Your Ref: OWPC4117
Our Ref: BR/208/14/PL 18-08-2014
Please ask for:
Mr S Davis

Construction of 1No. 2 bedroom chalet bungalow
Land adj to 65B Gravits Lane Bognor Regis

Thank you for your internet representation made on 20th October 2014 which has been recorded as '**an objection**' with the comments as follows:

REVISED PROPOSED PLANS AND ELEVATIONS
FOR LAND ADJACENT TO 65B GRAVITS LANE

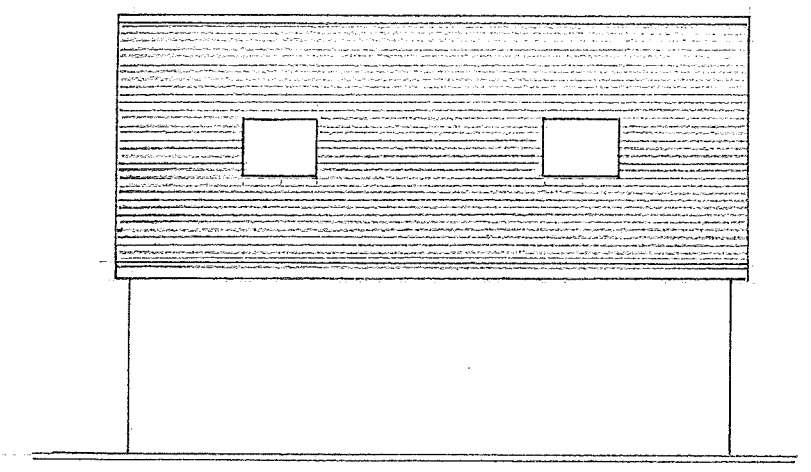
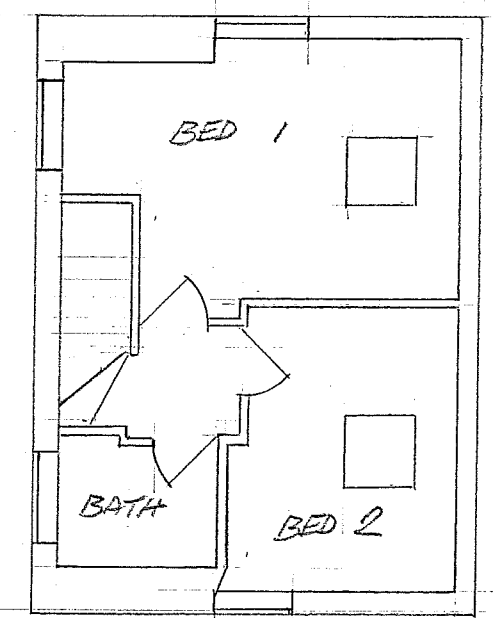
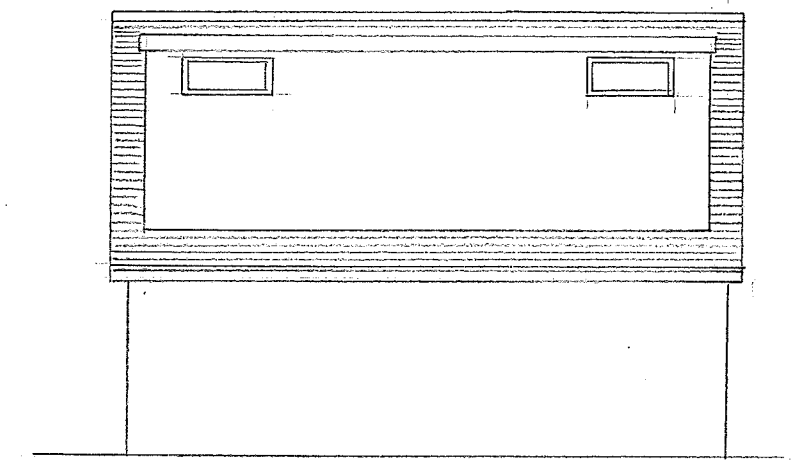
Also have read today that the retention of dormer has be refused on the grounds too large and looking out of proportion to the rest of street. Looking at the new build this too would have the same construction and feel this dormer on the new build would also look out of place to street, so object that this property not to be built. This ground is too small for a house to be built to look like the same size as all the rest in street, and too small inside for living arrangements and if a family to live there not enough ground for recreation. Many thanks Anira

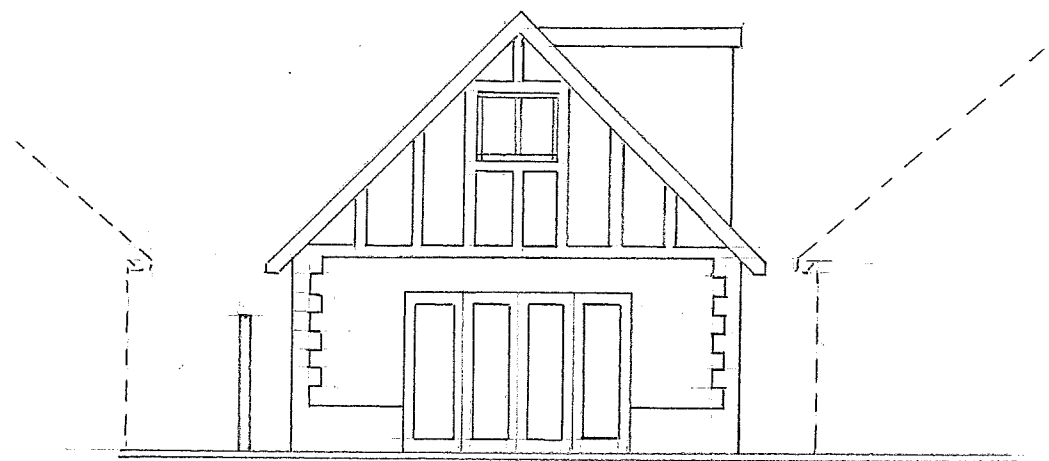
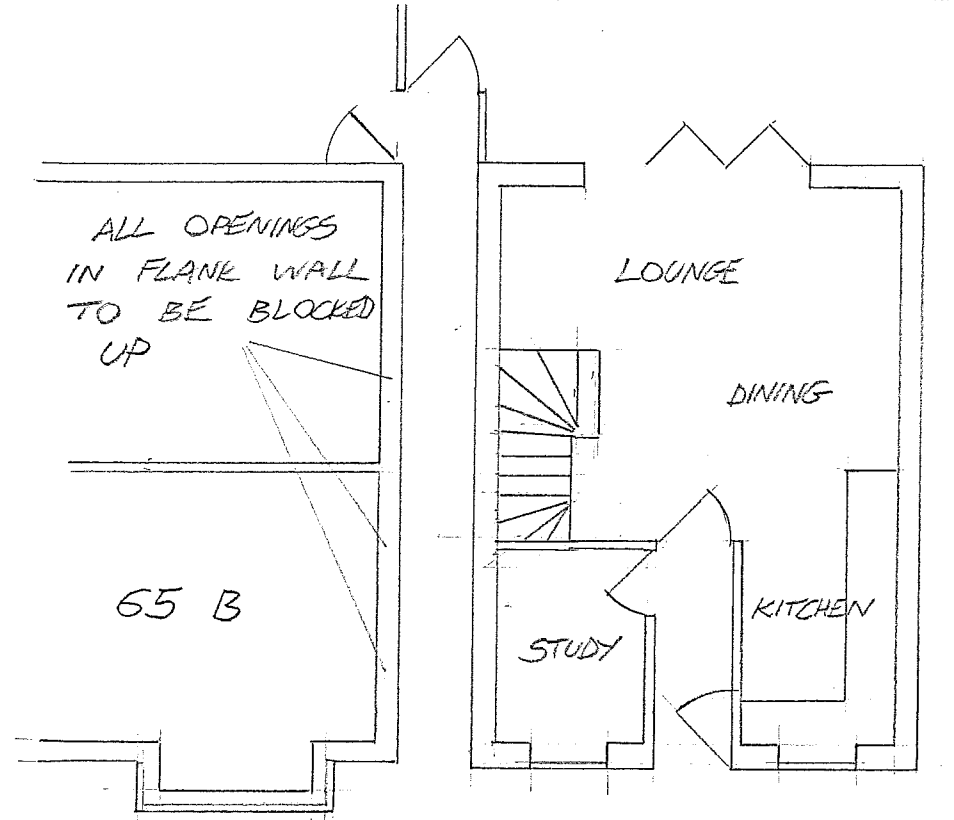
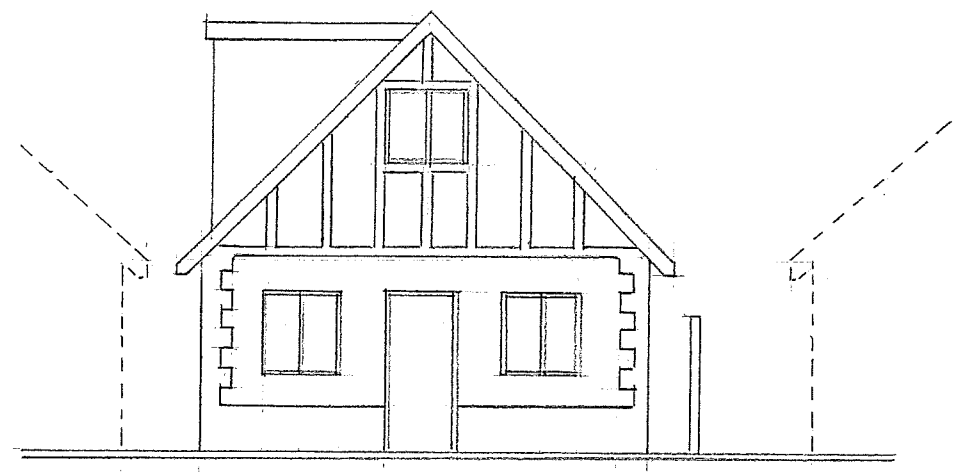
Further looking at plans of proposed build, have noticed that back windows and velux windows proposed would be onlooking our property. At present from the houses along gravits lane we do not have any windows onlooking our back garden. With this new build the top back window will be overlooking into our garden and not giving us our privacy that we have at present, so am very worried and concerned. Also the velux windows will also be looking onto our velux windows and I feel our privacy will also be taken for looking into our upstairs area.
